**HISTORIC PRESERVATION BOARD
CITY OF PORTLAND, MAINE**

**WORKSHOP
107 PINE STREET**

RE: August 2, 2017 **Workshop – Preliminary Review of Garage Addition
(Second Workshop)**

Address: 107 Pine Street

A2

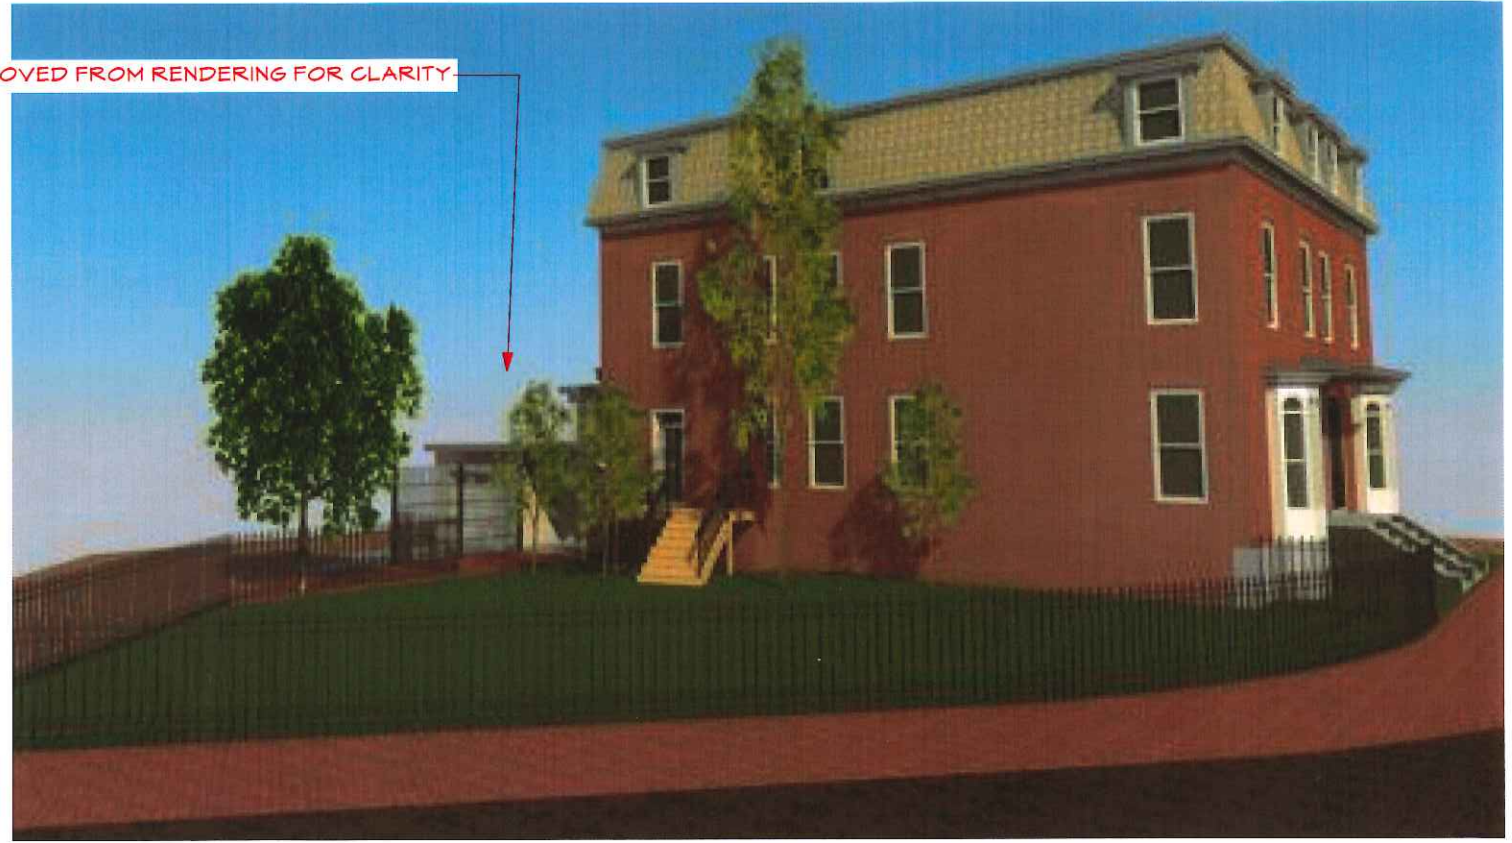
Staff wonders if the proposed addition of a porch, a door, and stairs to the main house may generate more discussion, in that they are attached to the original structure in a location that is potentially quite visible. The garden undoubtedly provides some vegetative screening, but the height of the house makes for a visible deck, railing, and flight of stairs – calling for a simple, quiet treatment, not a grand descent to the garden. That said, there is nothing in Mr. Whipple's concept that indicates intent to call attention to the new element, but staff believes a recessive approach is called for.

- Garage door choice
- Window and door choices and specifications
- Final trim dimensions and proportions
- Railing, trim, and skirt detail for the new porch (the drawings do not show any skirting for the deck or stairs at this point)
- Details on the rear fence changes and the proposed trellis.
